TECHNICAL NOTE

PROJECT	:	Land adjacent Sefter School House, Sefter Road, Pagham
NOTE REF.	:	Acl640/21023/TN
NOTE TITLE	:	Additional Information requested by the LLFA
AUTHOR	:	Tafari Lewis
APPROVED	:	Tafari Lewis
DATE	:	11 th March 2022

CAD Map Topographical Survey

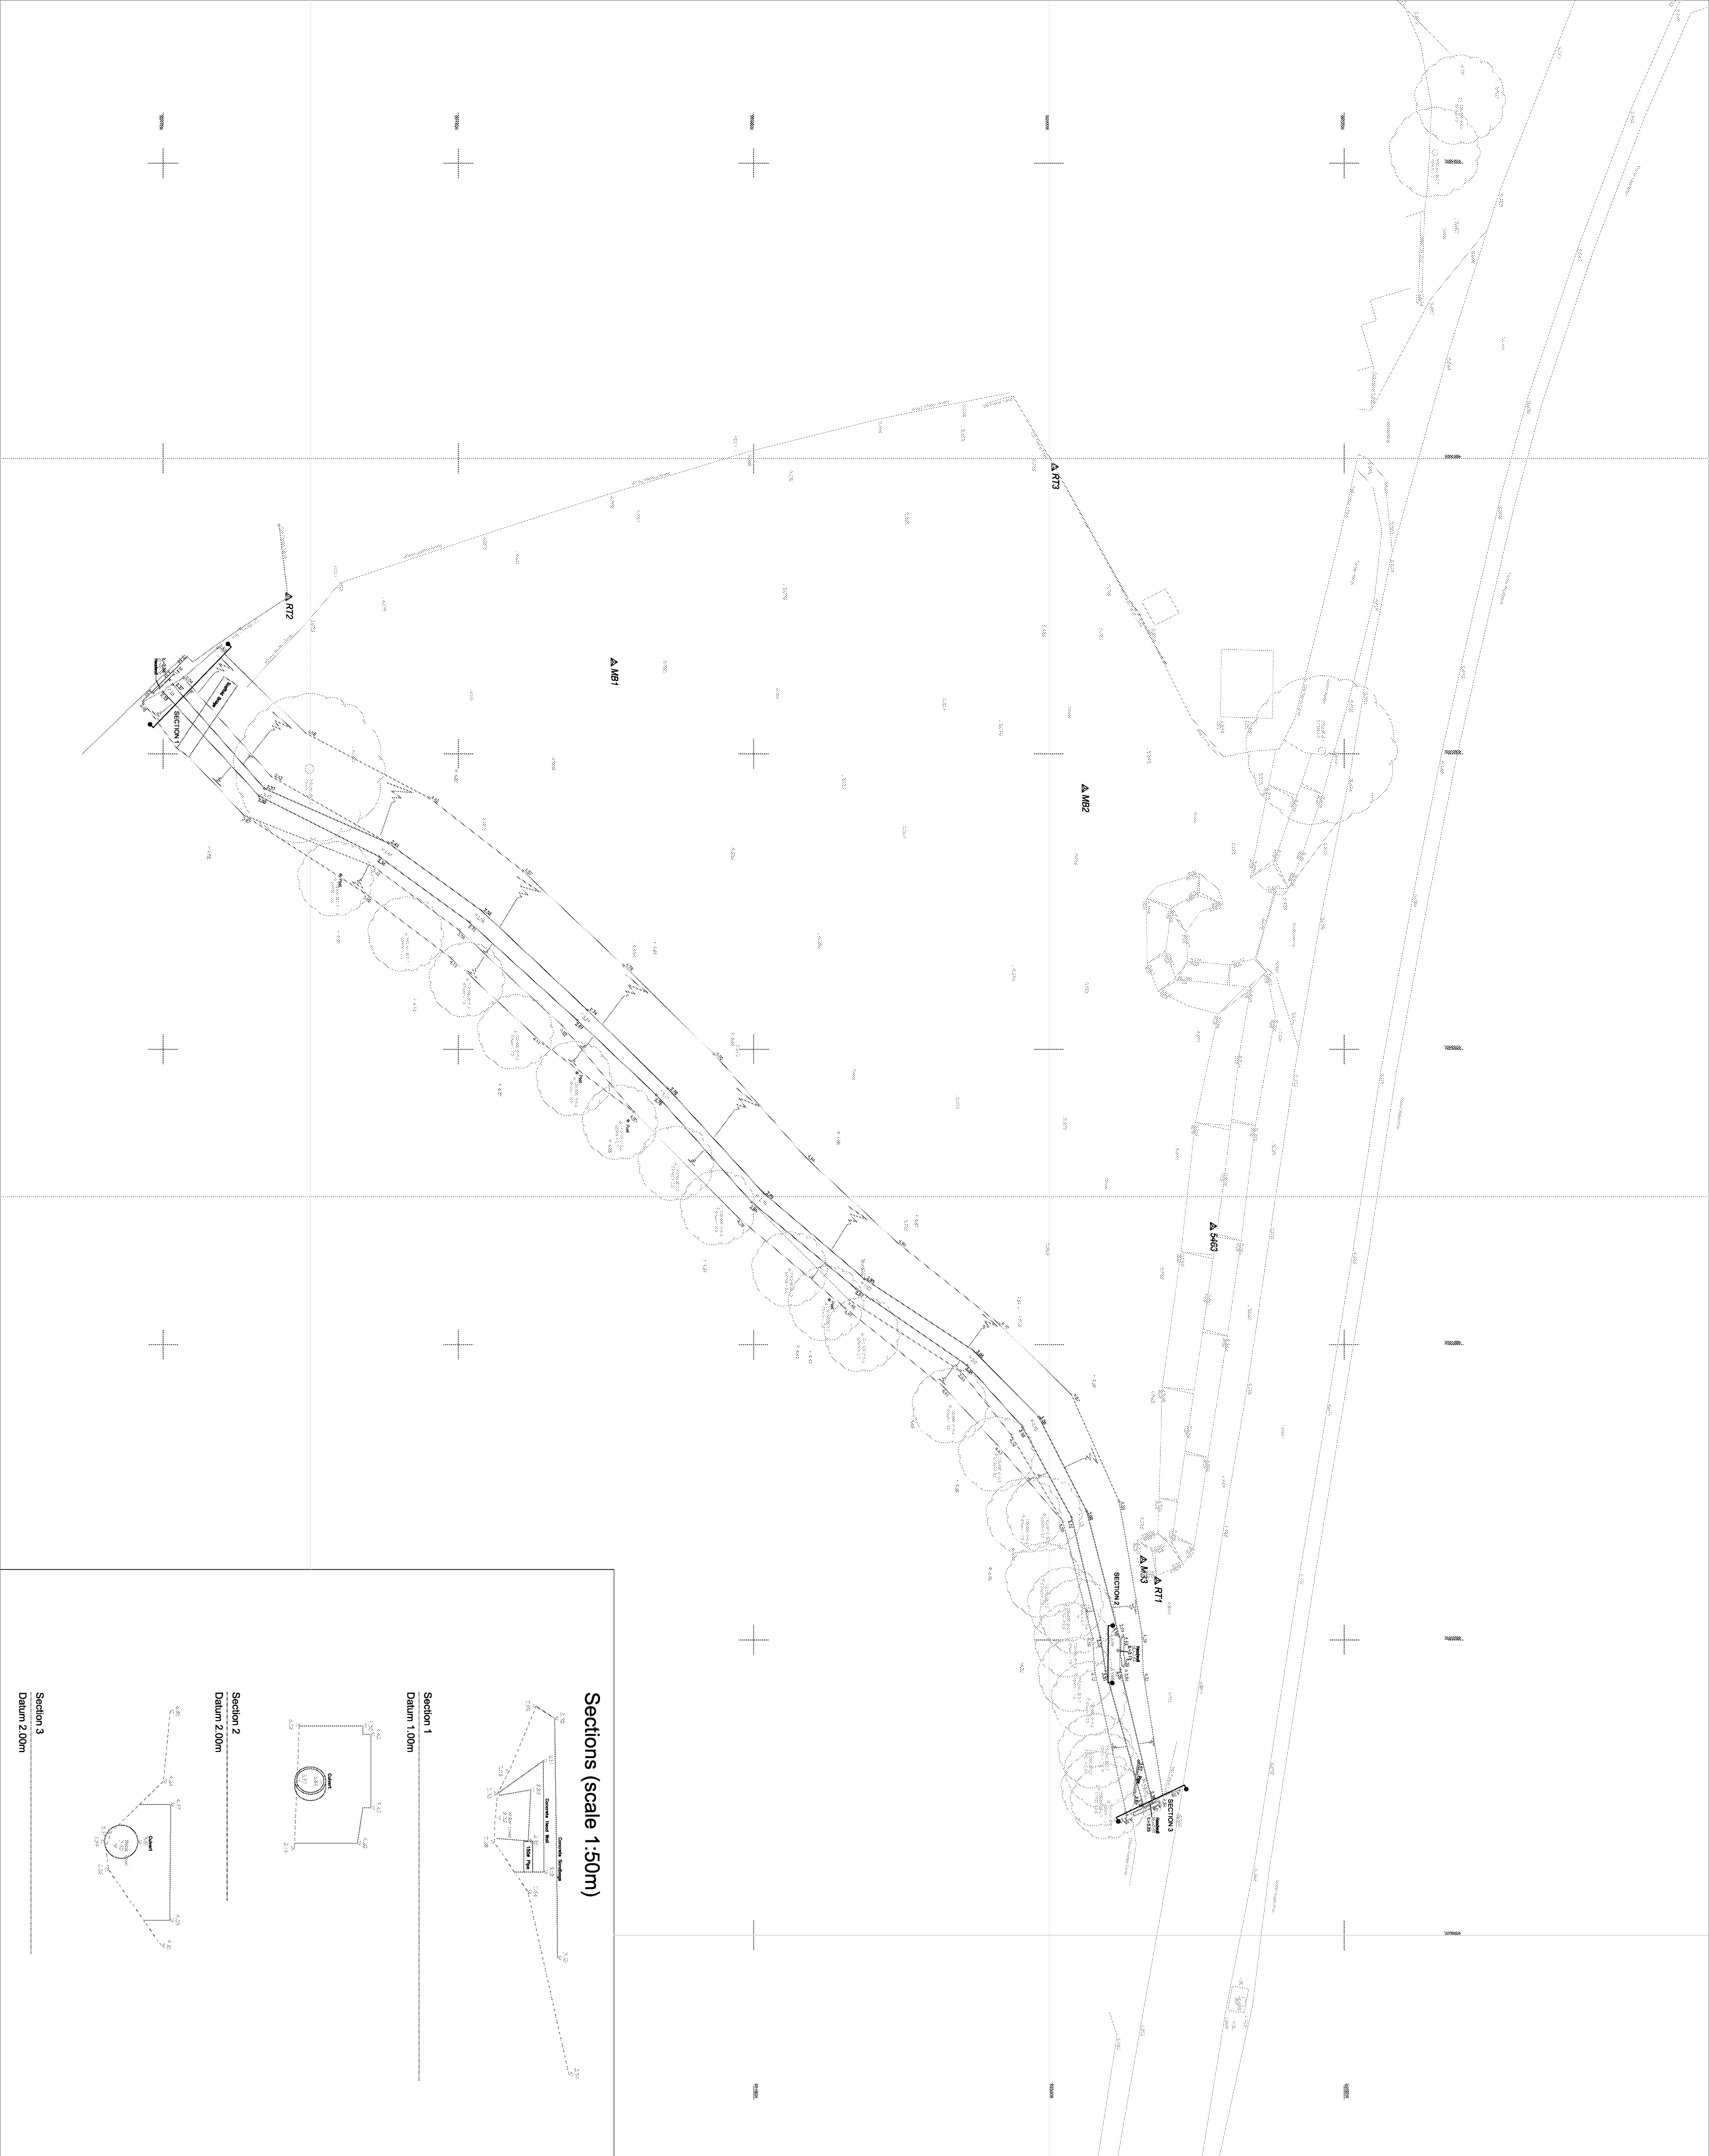
"We note that the levels of the ditch are shown to drop away sharply nearly the point of proposed connection. Please check all ditch levels on site. Please also provide downstream culvert invert levels, as well as soft and hard bed levels of the watercourse. An extended outfall pipe is proposed to get the discharge to the area where the watercourse is deeper. However, it may be that soft bed levels are shown upstream and that a discharge point closer to the hydrobrake, and drainage features is actually achievable with necessary maintenance completed to the watercourse."

At the time of this response additional topographic data was unavailable to check ditch levels on site together with the downstream culvert. The drainage scheme has therefore been based on the Medlams Surveys limited Topographic survey conducted in December 2019 (reproduced within **Appendix E**).

The additional survey information has been requested from the developer and once received shall be checked accordingly.

The current design which is based upon available stream levels has therefore been re-submitted and shall be reviewed once the additional survey requested has been provided for us to review.

Typical Section Through Light Duty Permeable Block Paving Showing

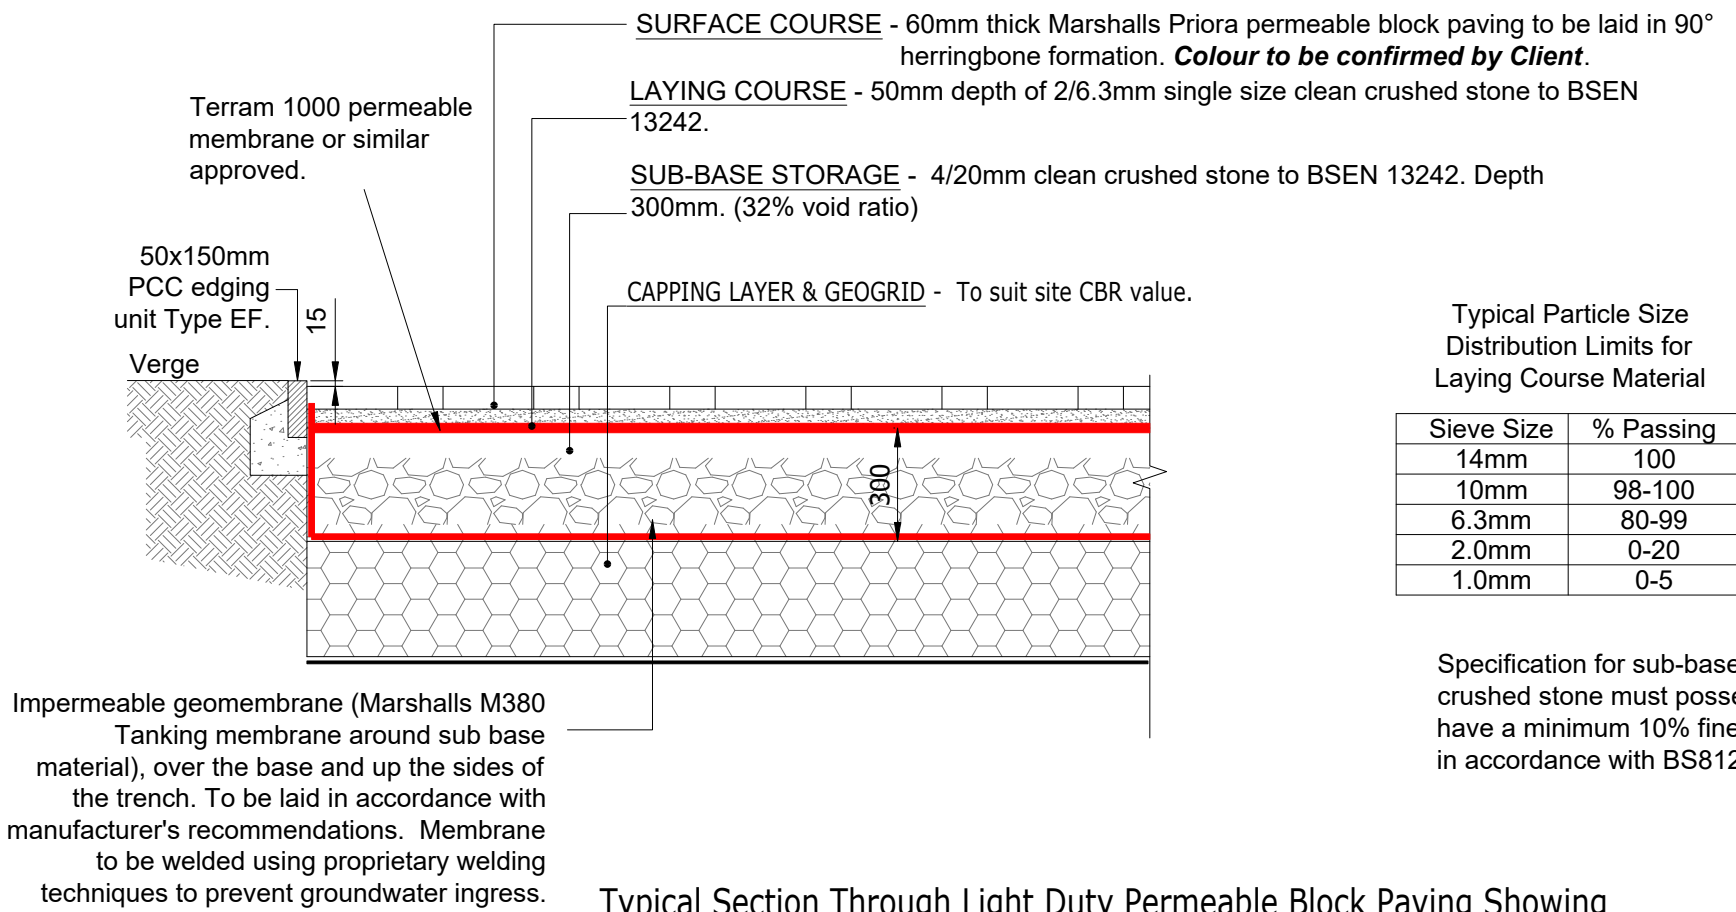
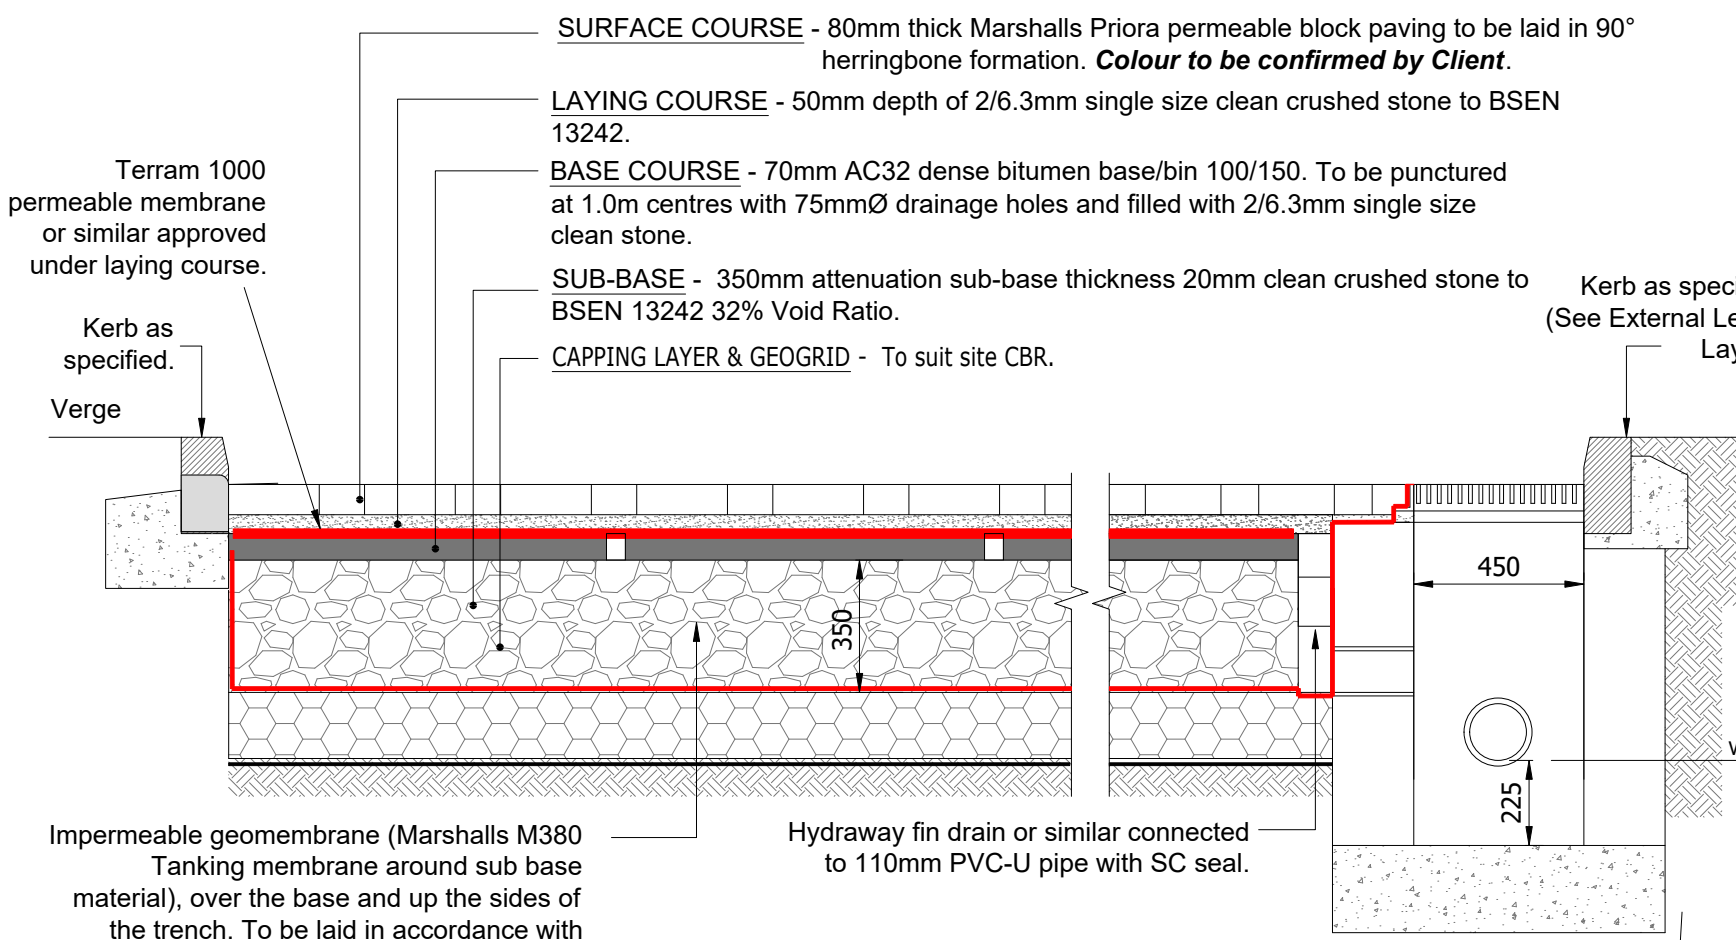
"Please supply site specific construction detail drawings of permeable paving, pipe bed and surround, gullies, manholes, catchpits, attenuation pond (a minimum of two perpendicular cross sections), attenuation tank, headwalls to basin, hydrobrake, outfalls to watercourse, etc."

A full set of site specific drainage construction details has been included within **Appendix H**.

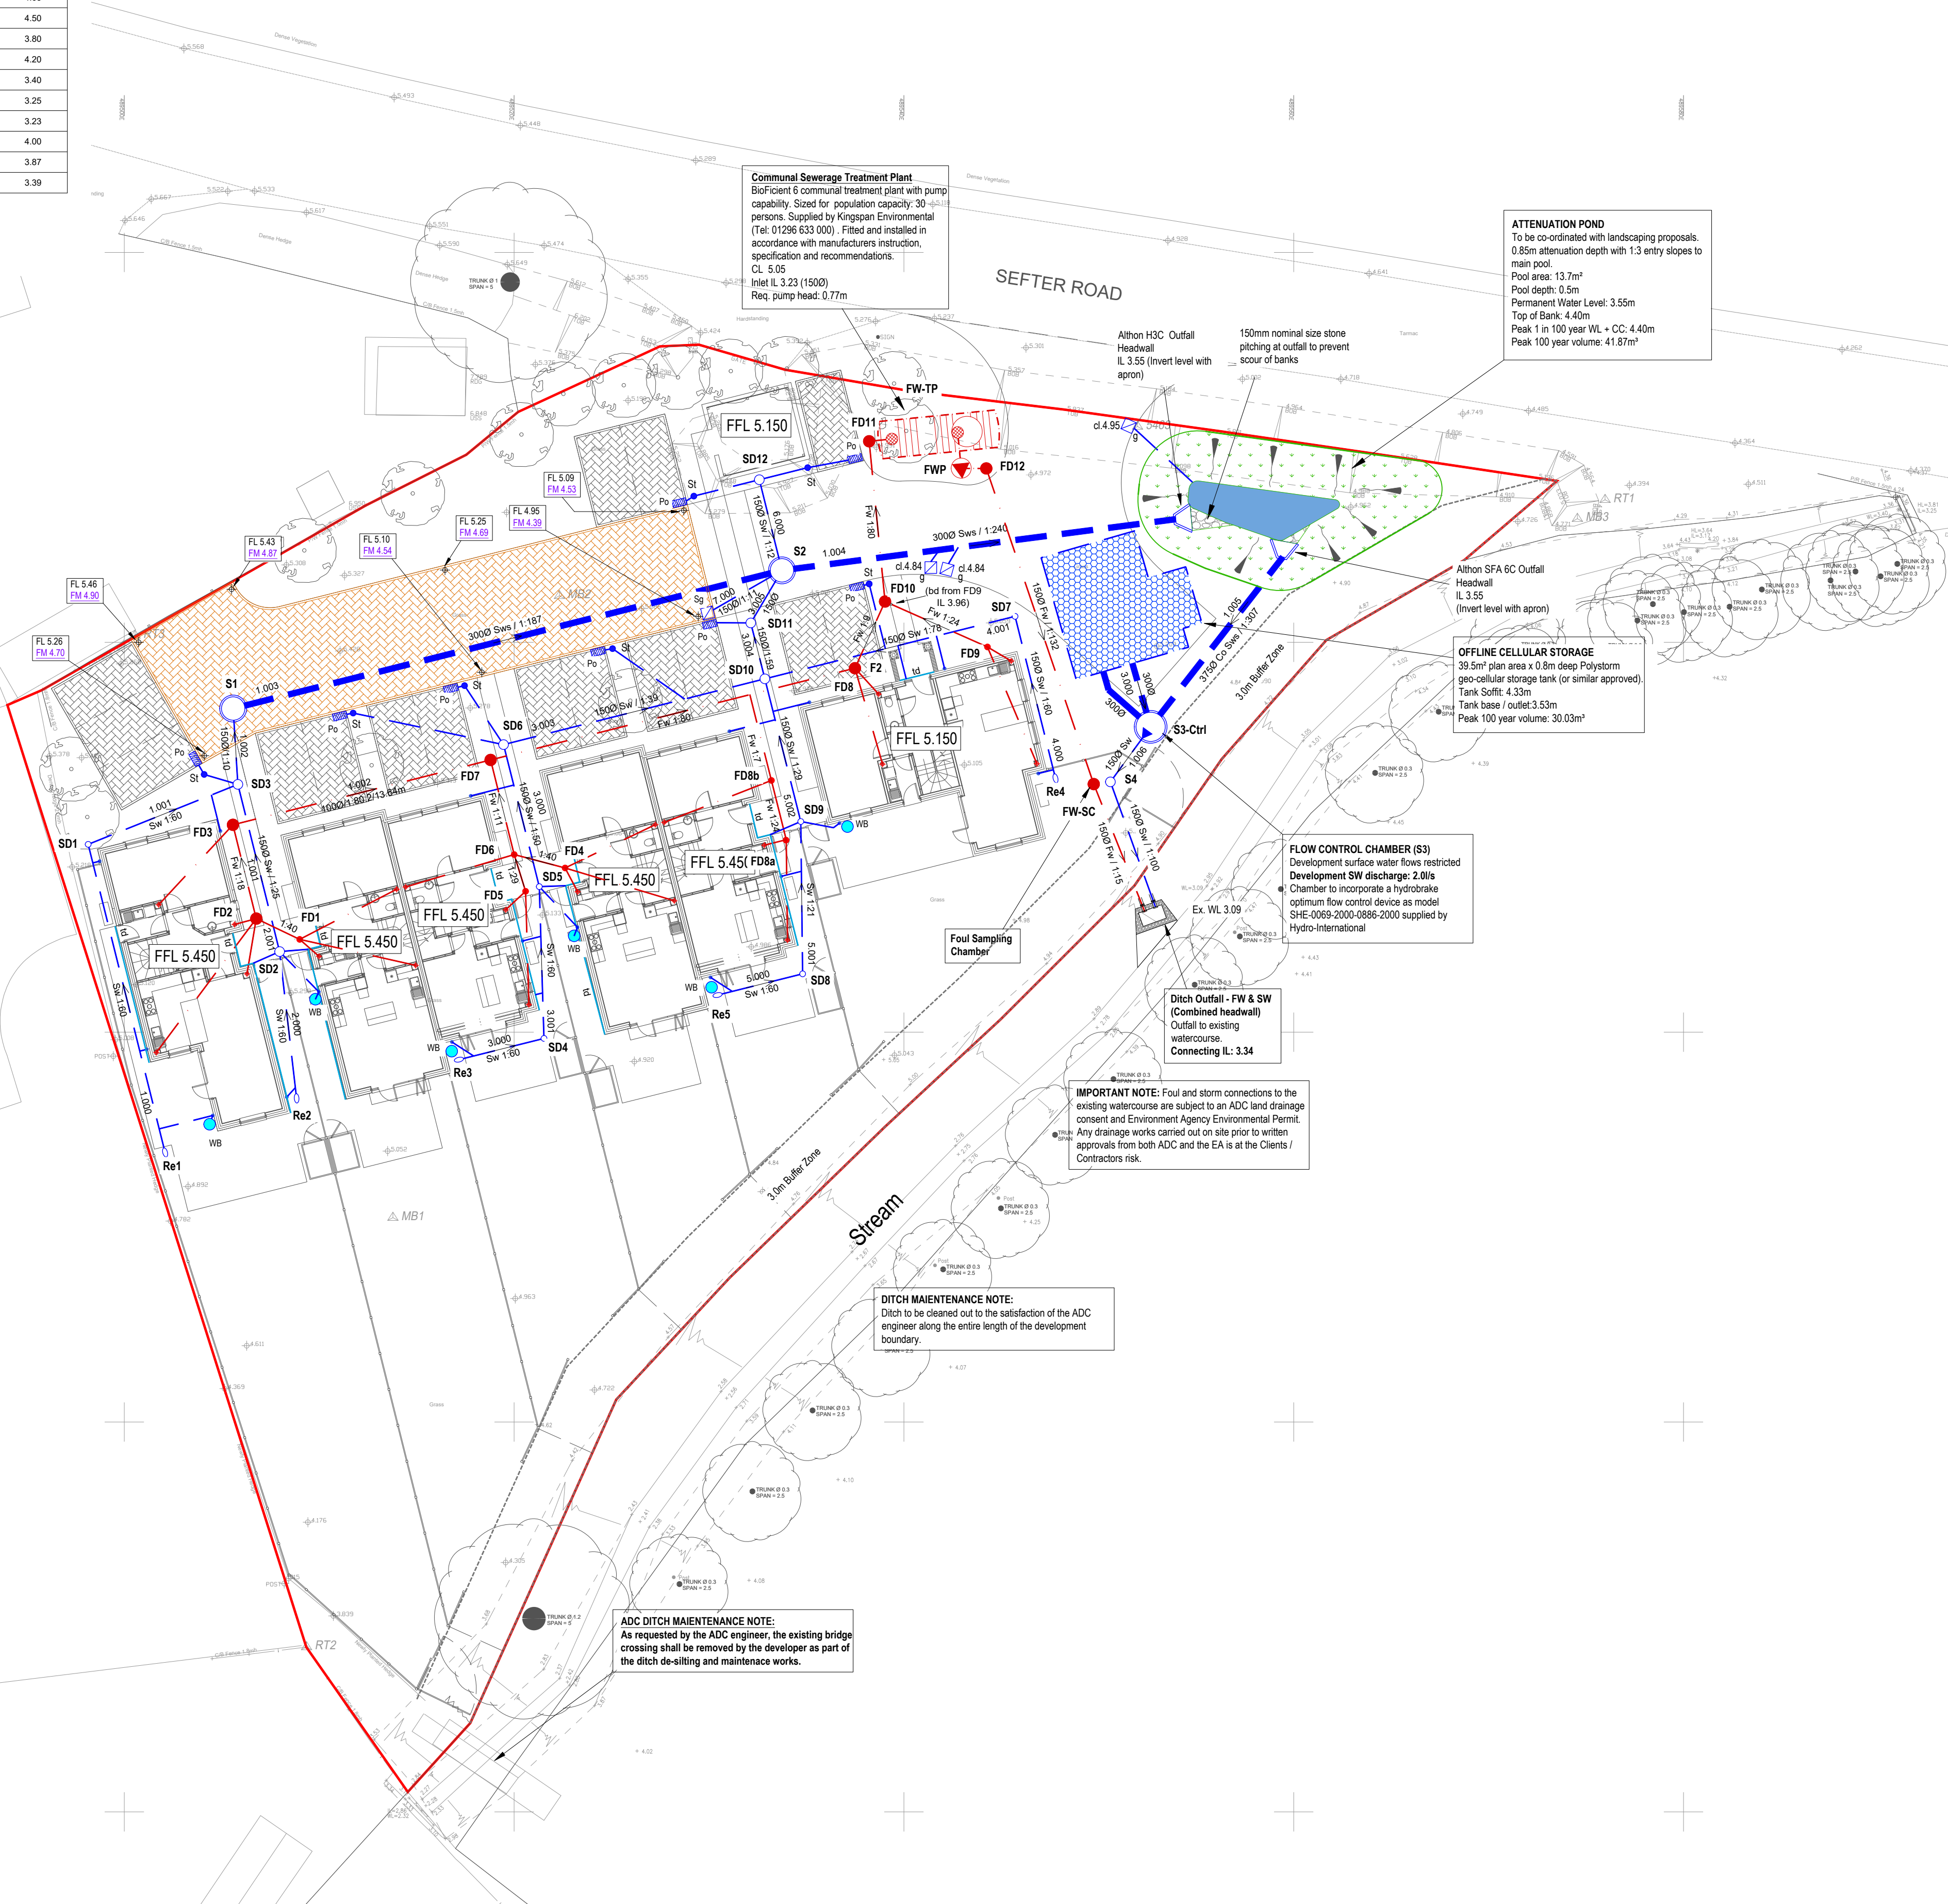
"The proposed invert levels of outfalls are not clear (please clearly define them on plan), however upstream manhole inverts show that outfalls will not meet our minimum requirement for clearance between bed level and invert level of outfall pipes. As an absolute minimum we require 150mm".

"Finish and formation level of permeable paving must be labelled on layout plan".

"All pipes must be labelled with diameter and fall".

"Please label gully cover levels on plan".

"Hydrobrake unit reference must be stated on plan".

"Please show connections from permeable paving areas to the piped network."

Noted. The outfall bed level is 2.93m aod which means the minimum permitted connection would be 3.08m at the outfall location. The designed network has been adjusted accordingly.

Finished and formation levels for the main access permeable paving have now been included on the updated drainage layout plan.

Noted. Now illustrated on the Below Ground Drainage Layout in Appendix F.

Noted. Updated accordingly

Noted. Updated accordingly

Noted. Updated accordingly
